Subject: RE: Attached letter from Kirklees Council regarding application number 2025/90689 at location Penistone Road/, Rowley Lane, Fenay Bridge, Huddersfield, HD8 0JS

I would like to advise that conditions 25 (retaining walls) and 26 (attenuation system) can not be discharge pending the approval of the necessary details, as stated below;

DRAWING TITLE: FENAY BRIDGE, HUDDERSFIELD (TANK 2)
2.0m Dp. MODULAR WATER
RETAINING TANK
PROPOSAL DRAWING

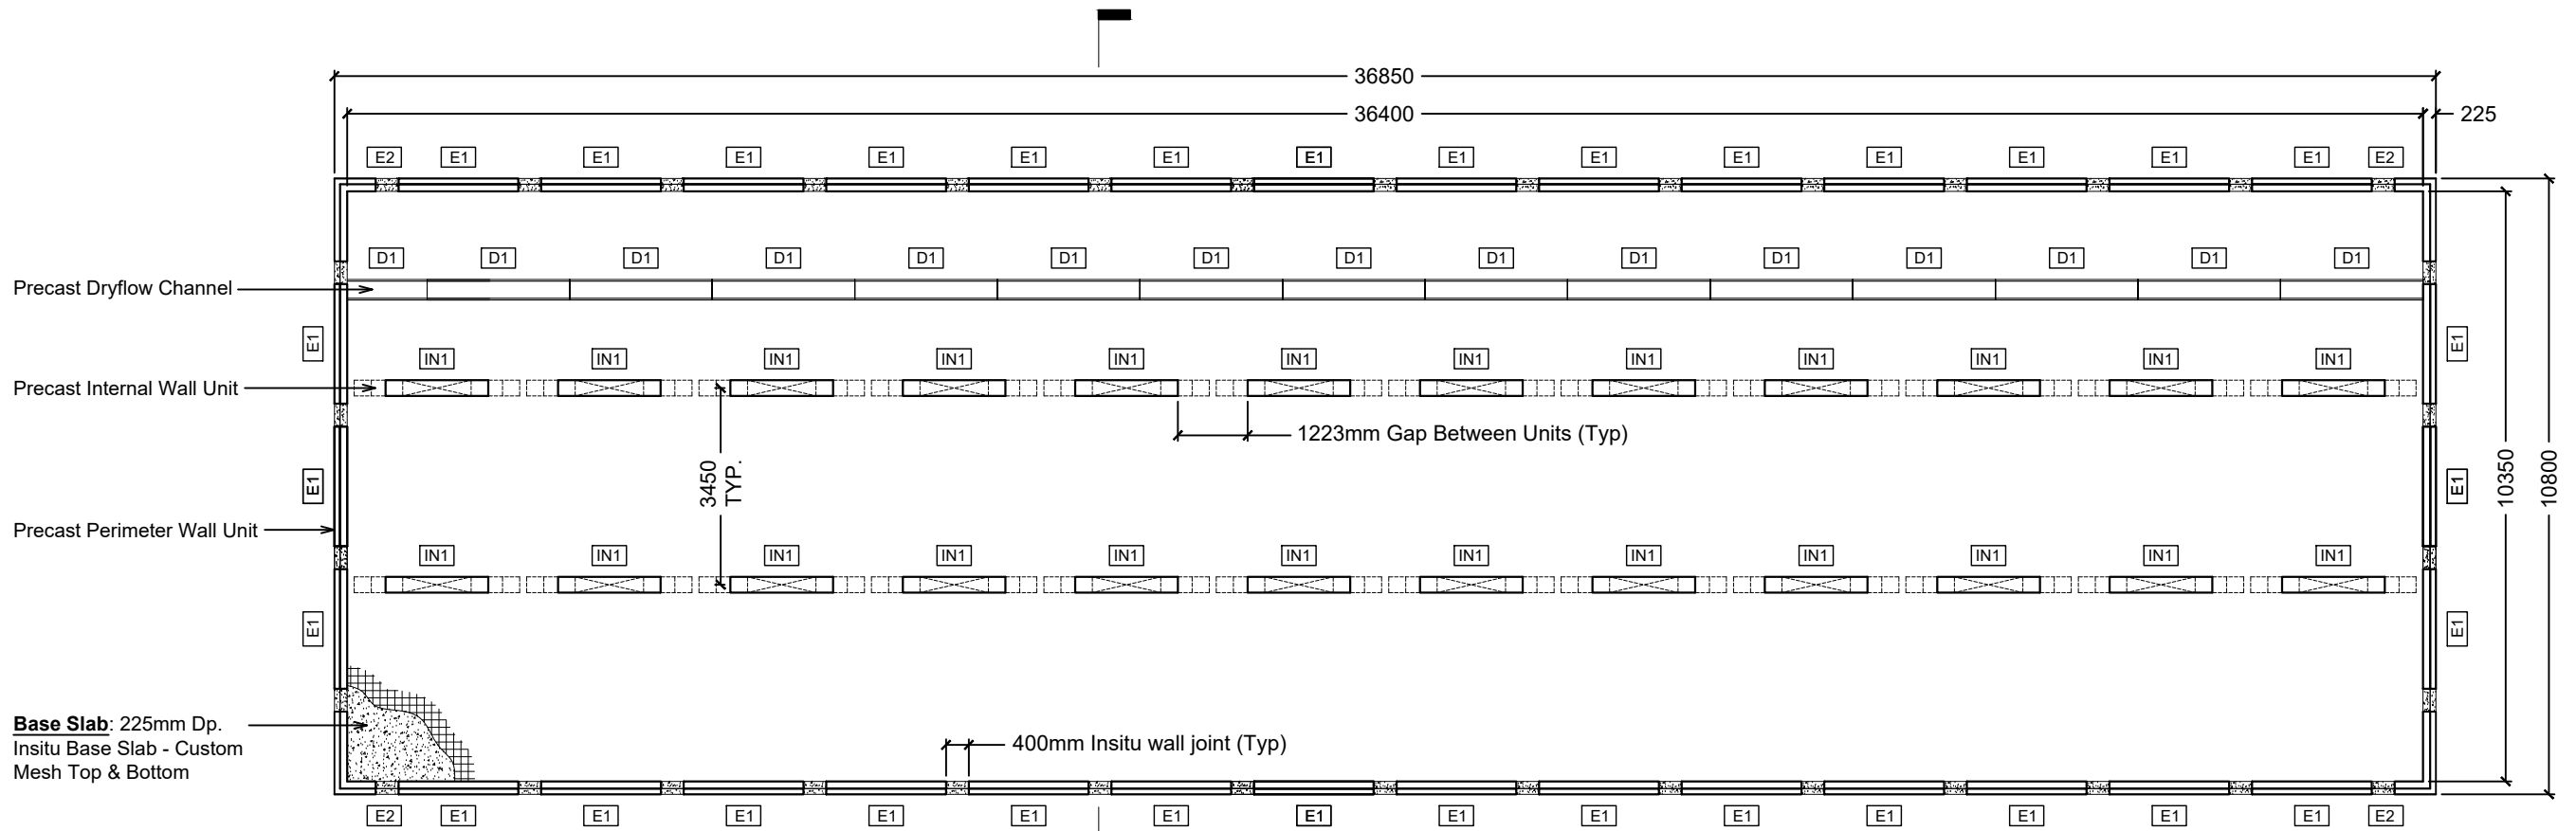
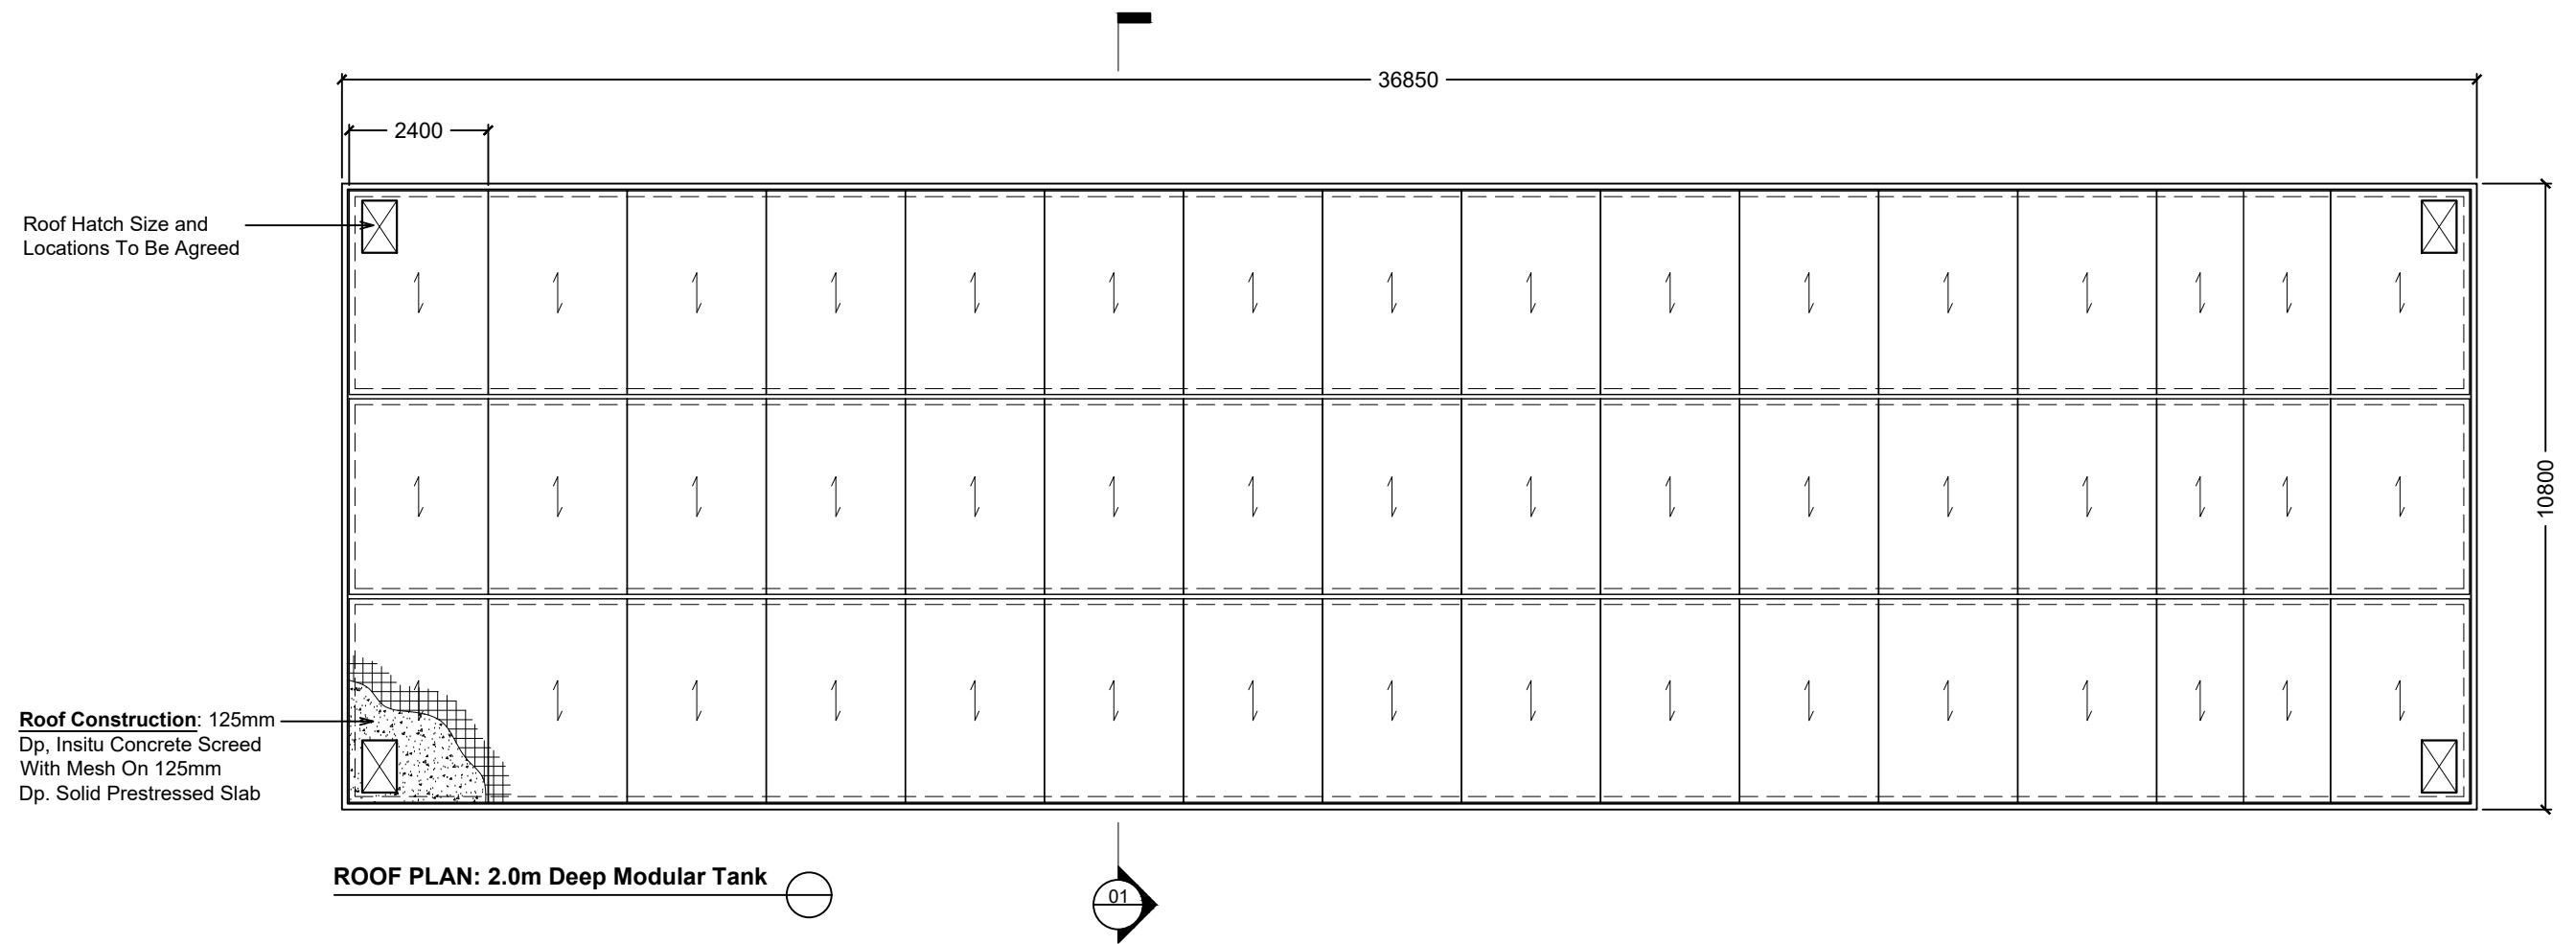
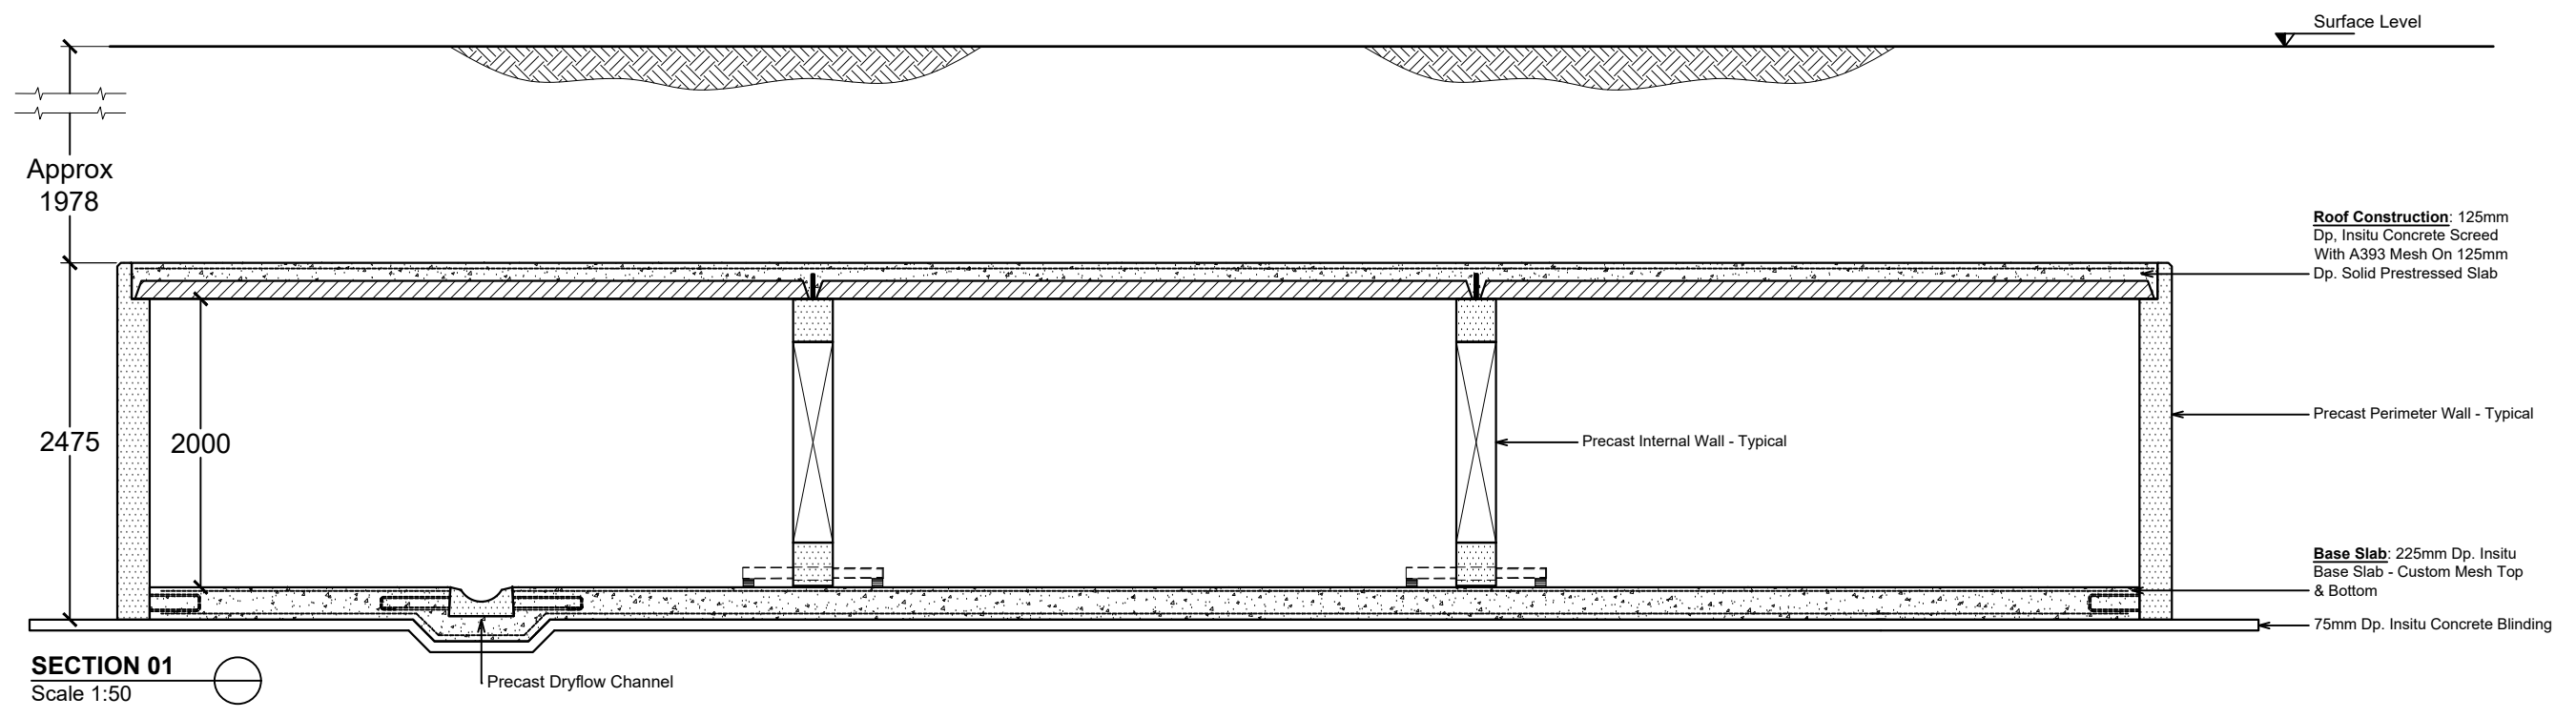
- 2) Suitably scaled and fully dimension X-sectional detail between the attenuation tank and the adjoining highway adjacent to plot 48 to ascertain whether the design of attenuation tank wall will be liable to a formal technical approval via submission of an AIP.
